From: Amanda Scholes on behalf of Planning.Responses
Sent: 02 December 2019 11:28
To: Planning Scanning
Subject: FW: Planning Application AW/246/19/PL
Attachments: LLD1845-ARB - LLD Response to Tree Officer comments.pdf

Planning Application Ref: AW/246/19/PL

Location: Land Adjacent to 34 Wakefield Way Aldwick PO21 3RS

Description of works: Erection of 1 No. 2 storey end of terrace house

PROJECT	Wakefield Way	DATE	19/08/19
TITLE	Site Plans	DRG NO	IBA/520/01
SCALE	As Noted	REVISIONS

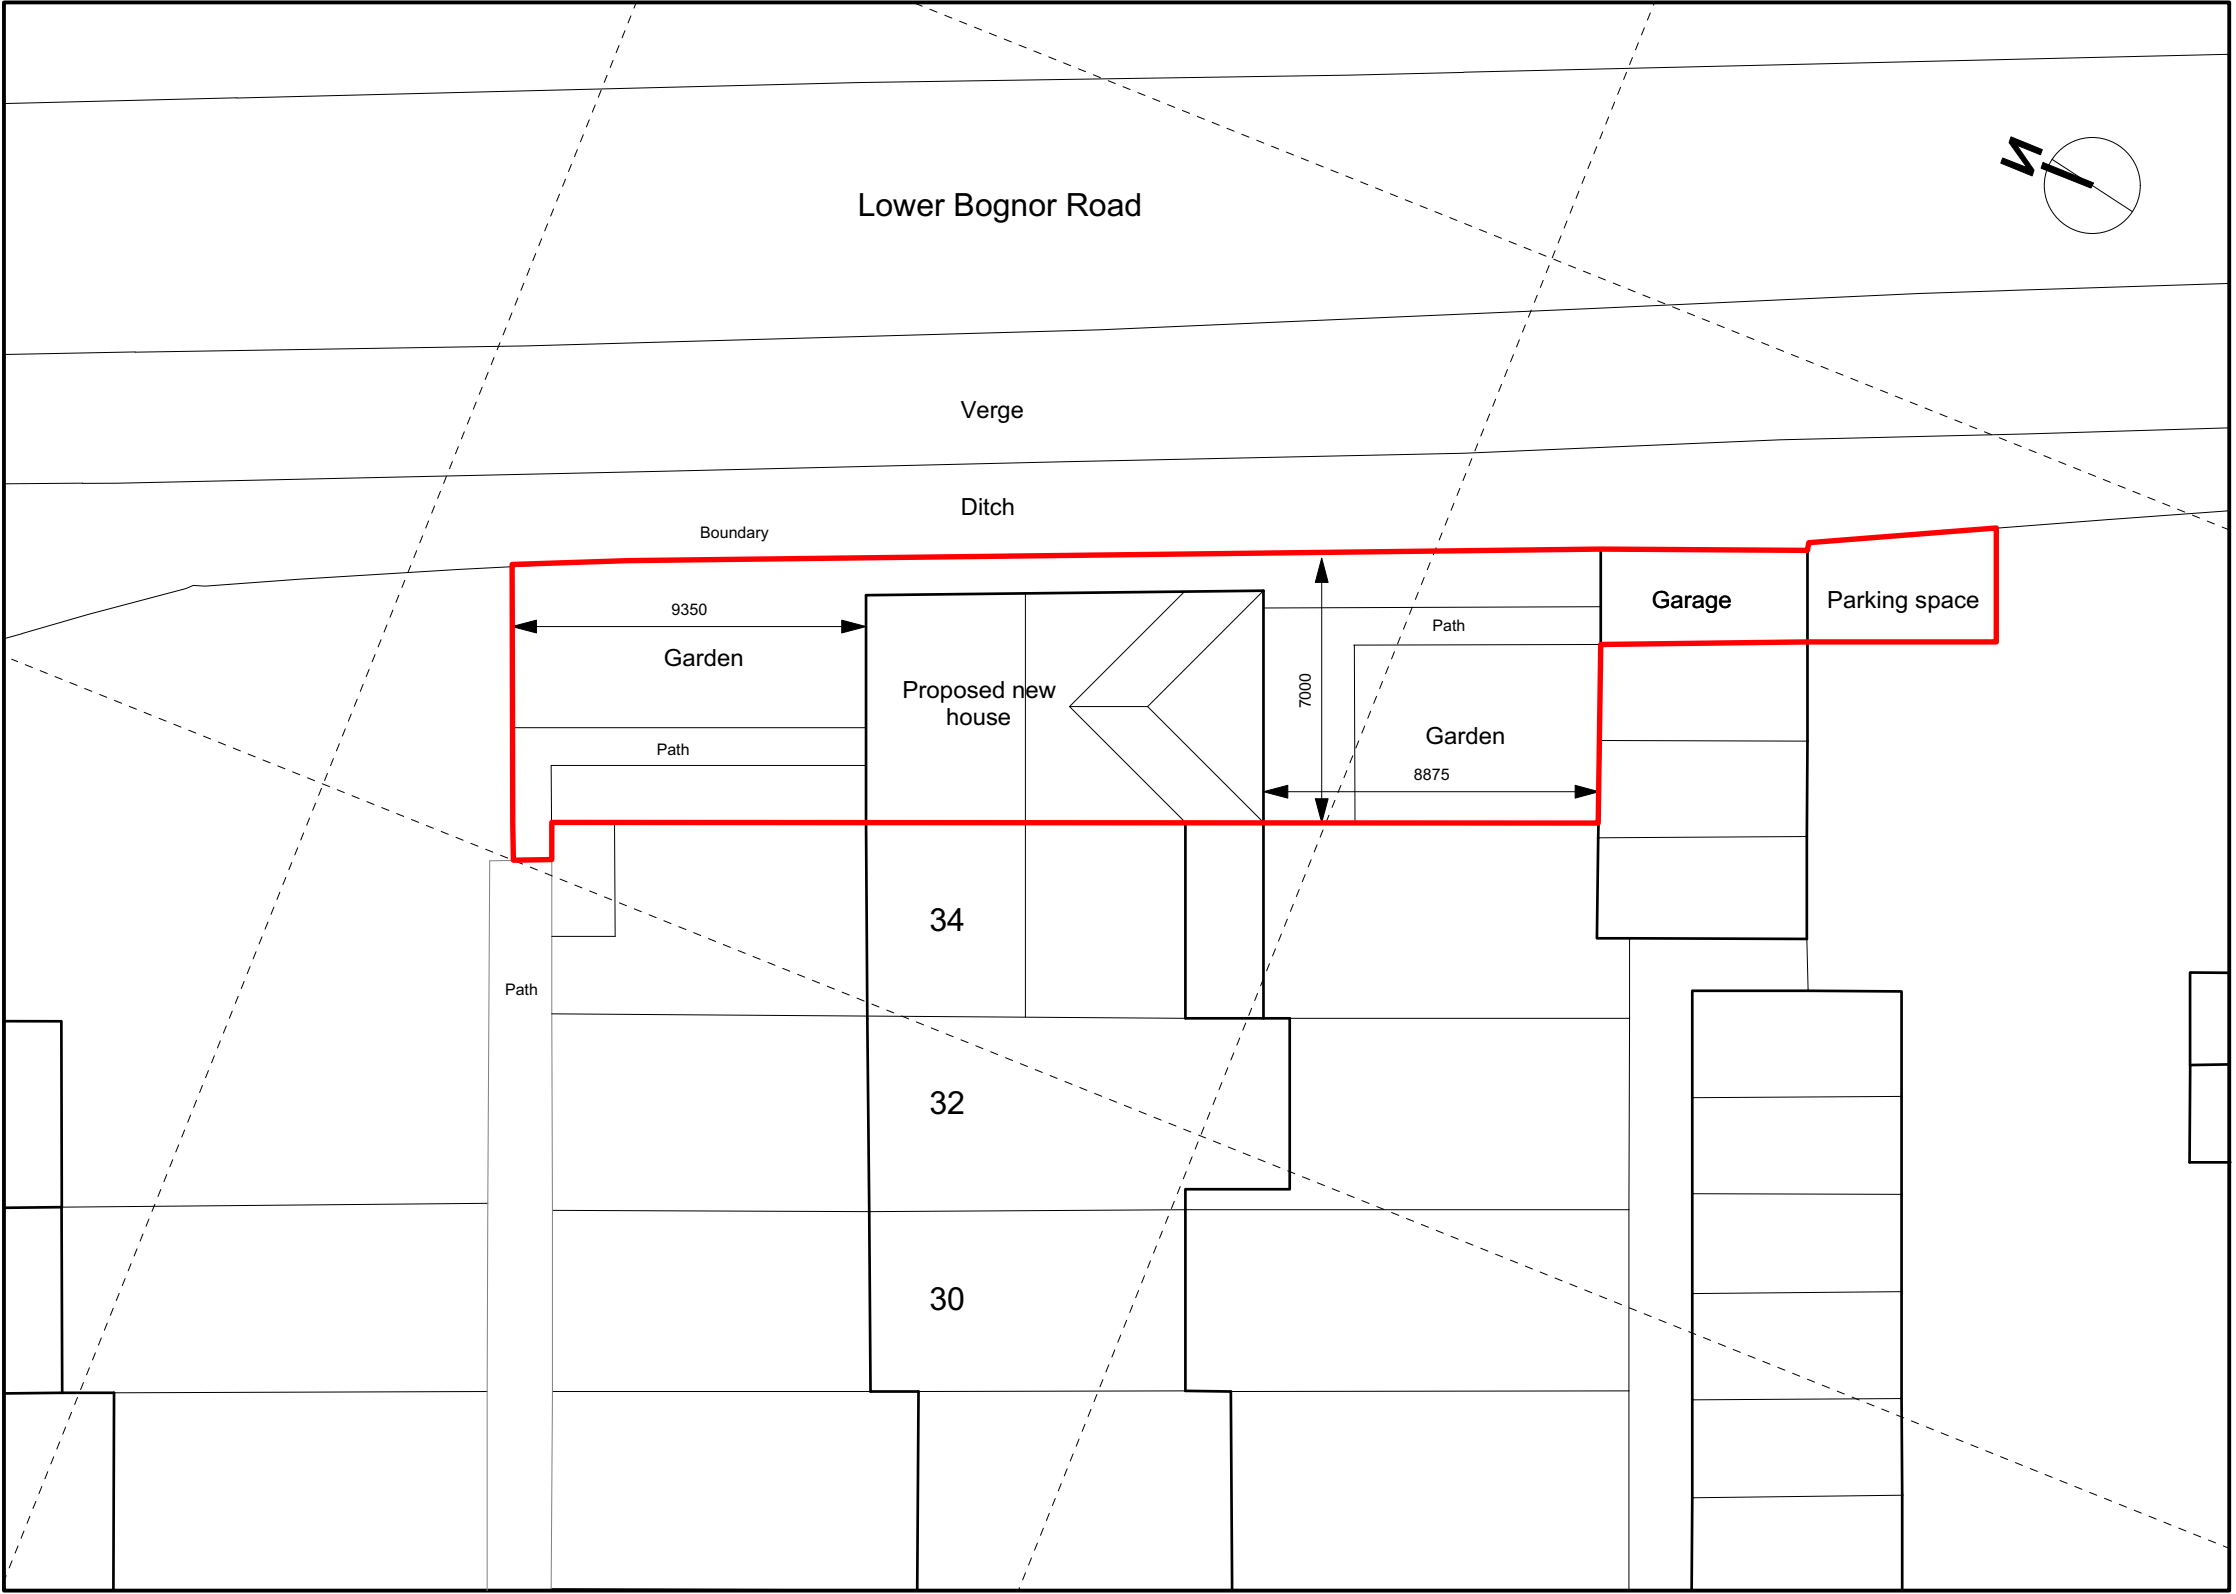
- The use of circular Root Protection Areas is typical and usually adequate but in truth is rarely an informative representation in the built environment. In this case it clearly does not reflect the likely area which contains sufficient roots and rooting volume to maintain the tree's viability. A revised polygon which abandons the inclusion of carriageway/footway and captures much more of the existing garden and verges would be a realistic representation. It follows that the actual extent of root protection area intrusion proposed by this scheme is far more extensive than that which has been illustrated on the TRP plan.

- I note from the Design and Access Statement that cellular soakaways are proposed (ideally to be 5m from built structures) and that should be situated outside of the anticipated rooting area of established trees. I have not seen where this is going to be located but clearly to the rear of the dwelling is going to be problematic, especially when you revise the RPA.

Any cellular soakaway can be located in the front garden outside of any RPA's, or in the rear garden of No 34 as this is in the same ownership.

Through the reference to the historic maps of the surroundings and the development site, the area appears to be utilised as agricultural / farmland until the late 60's/early 70's when the housing estate was built, therefore the true extent of the Root Protection Area of the tree T05 within the property can only be established through ground investigation such as excavation trial pits. We would recommend non-invasive root investigation within the area of the proposed foundation undertaken by professional Air Spade Investigation service to ascertain root distribution.

The proposed cellular soakaways will be located within the proposed front garden and outside of RPA's
